Submissions Report

Mixed-Use Development with In-Fill Affordable Housing

2-6 Pilgrim Avenue and 11-13 Albert Road, Strathfield

SSD-80432461

HEIGHT PLANE

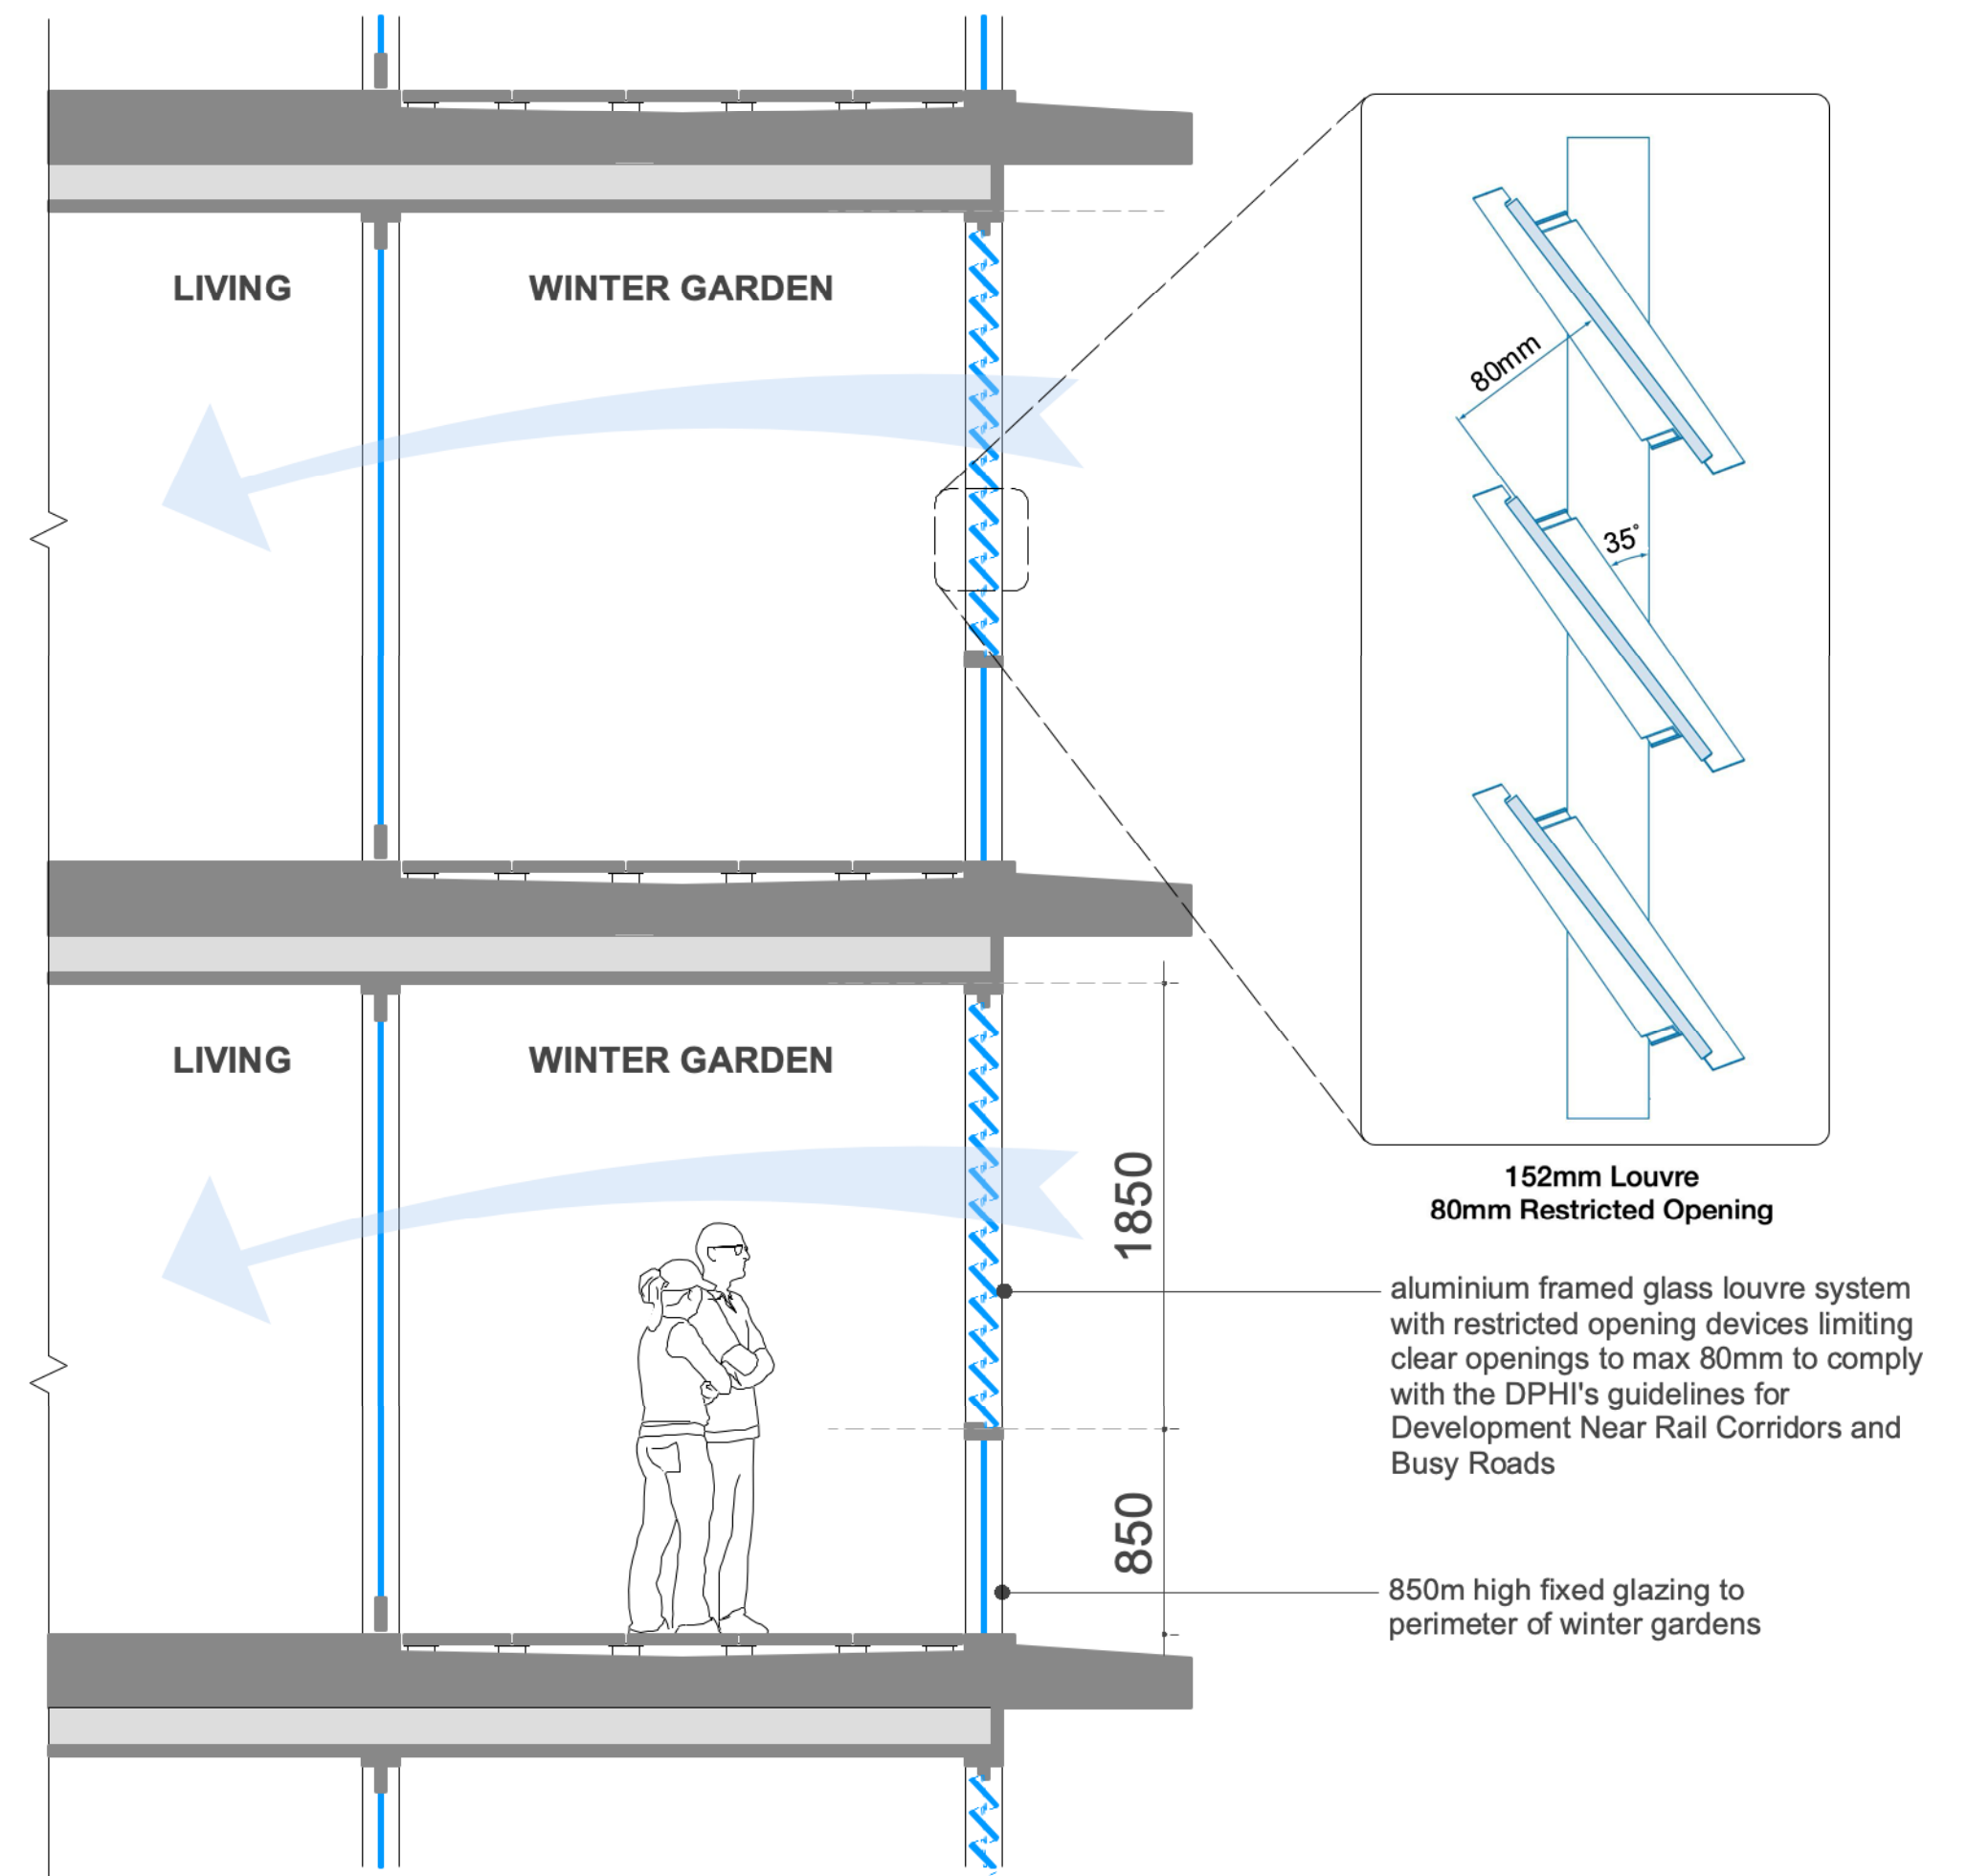
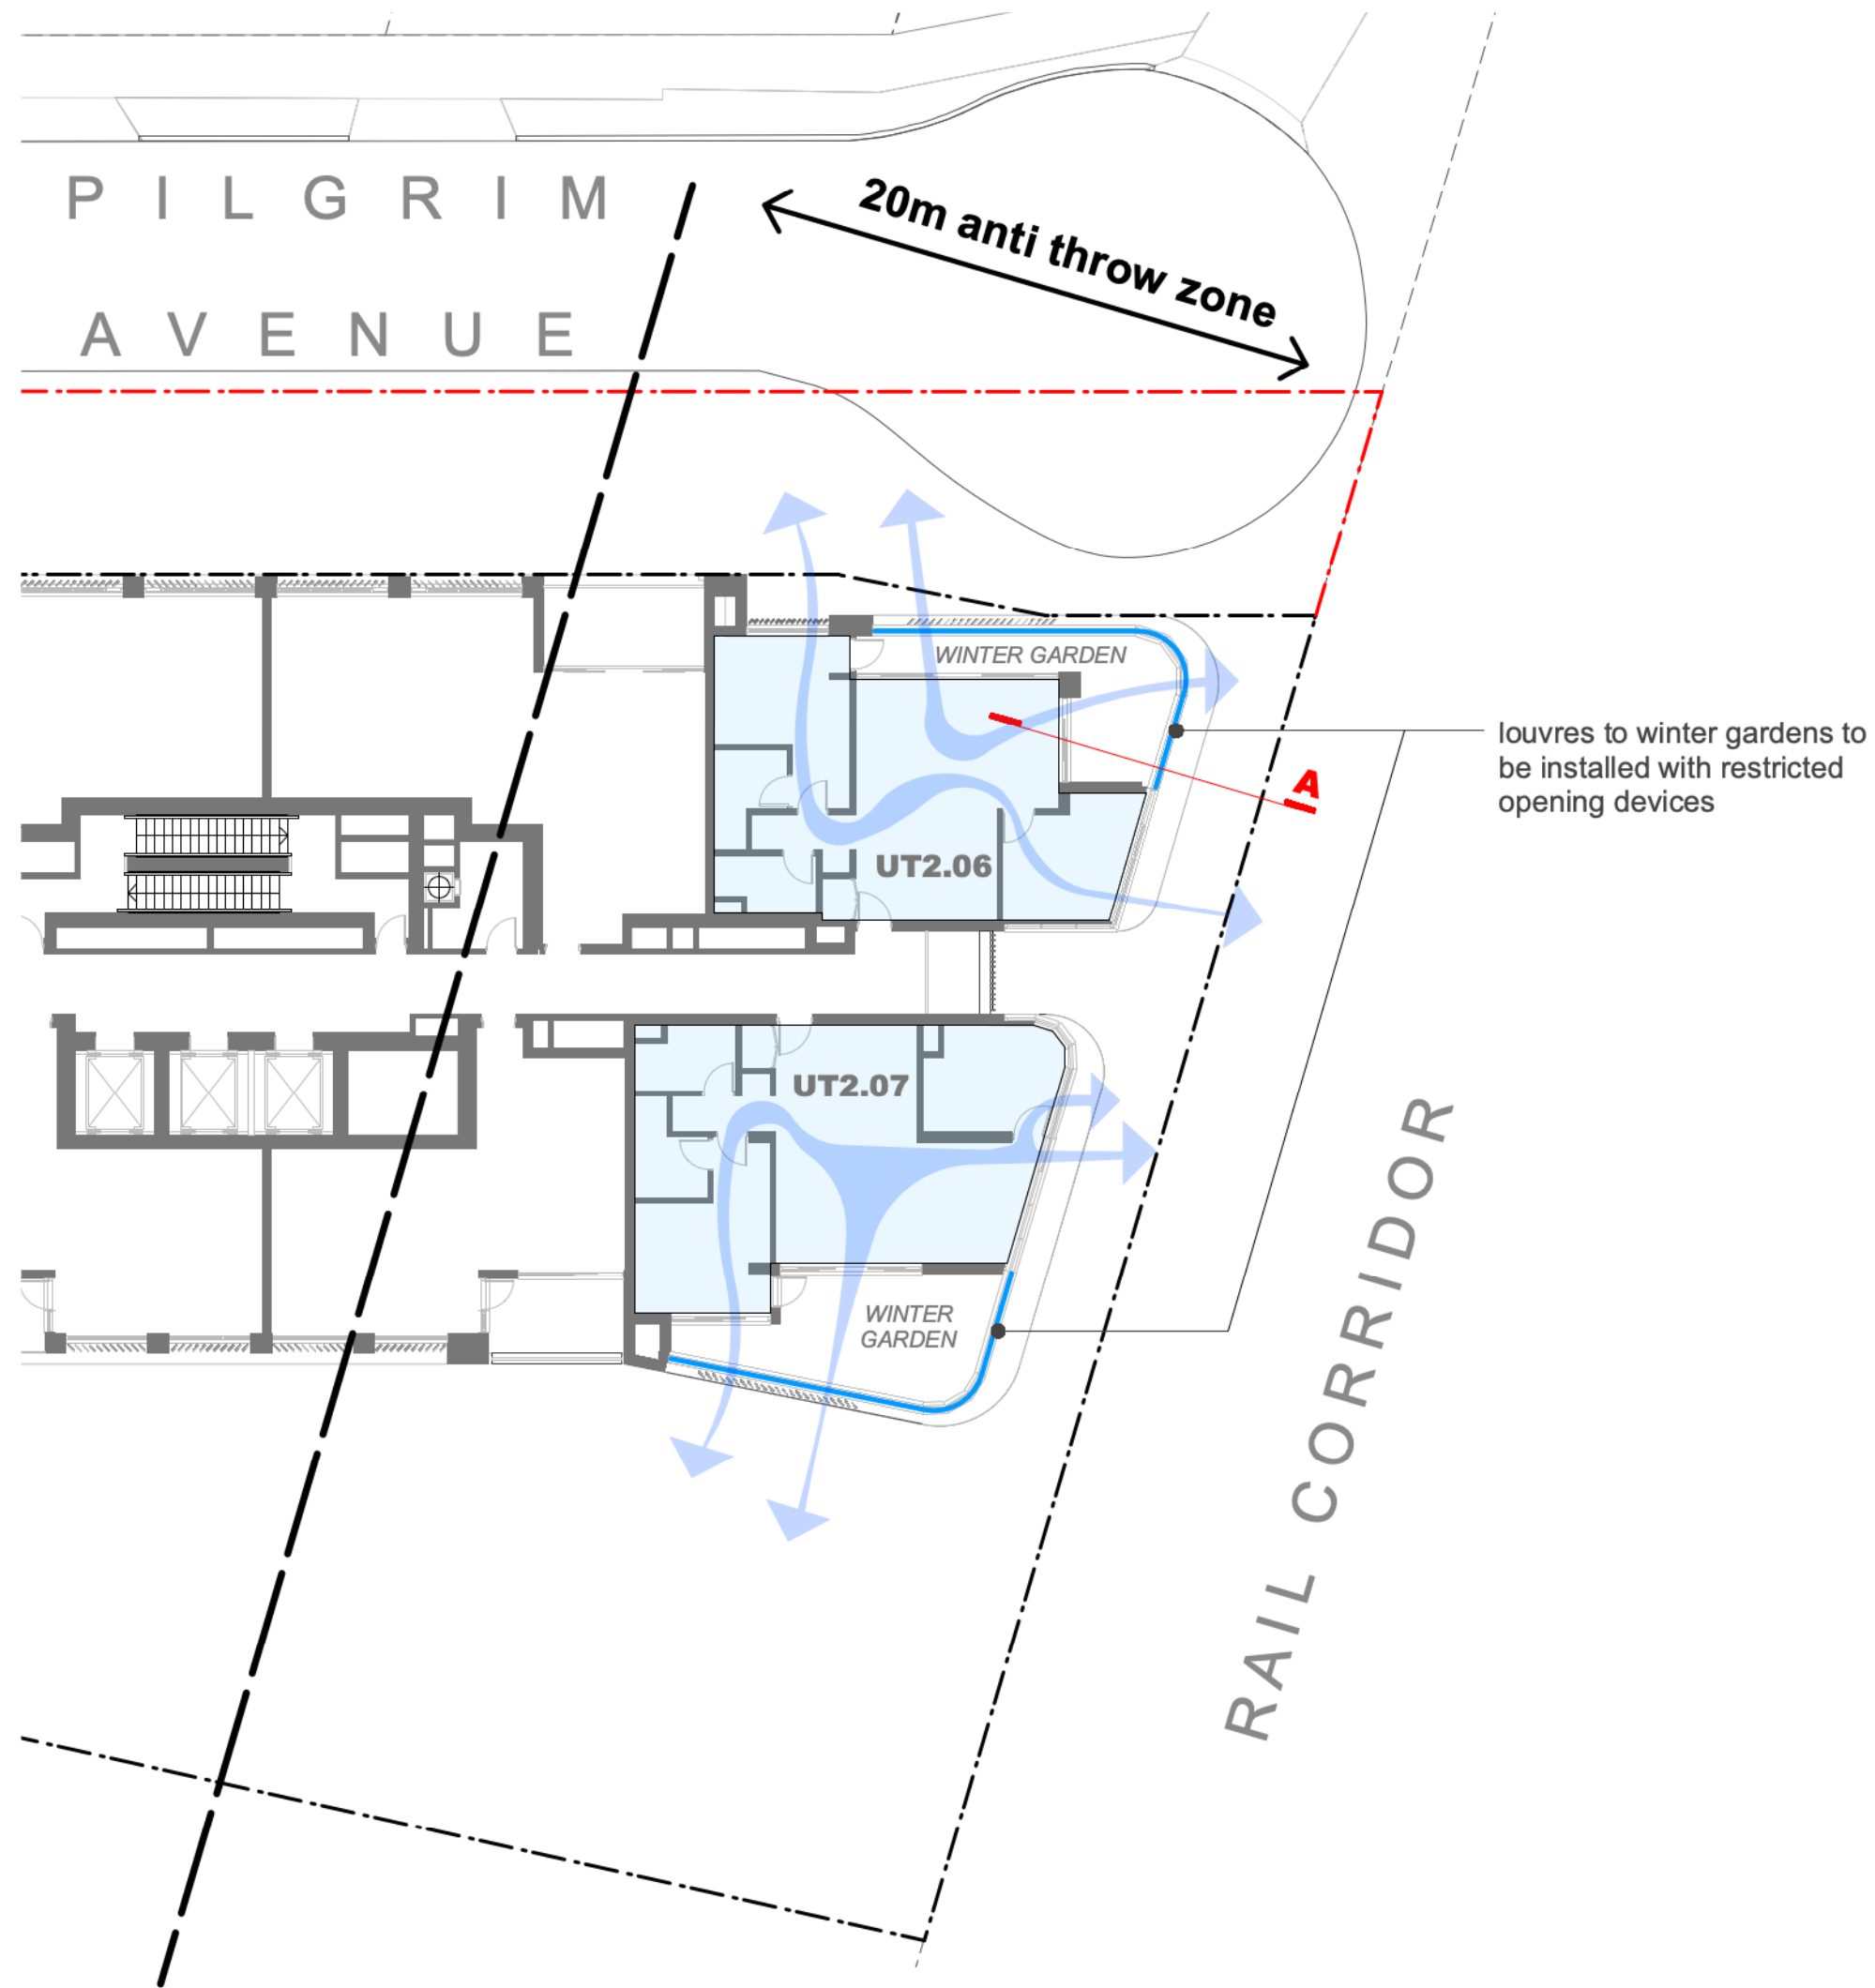
Matter Raised	Applicant Response
(b) Annotate on the Section and Elevation Plans the maximum height line of 70.2m and show the existing ground level to confirm the proposed building heights.	assessed in the EIS. In particular, it is noted that the GFA increase relates solely to the ground floor back of house areas and does not change the massing or form of the building in any way. The updated Architectural Drawings (Appendix B) include revised Section and Elevation Plans that depict the existing ground line and proposed maximum building height.
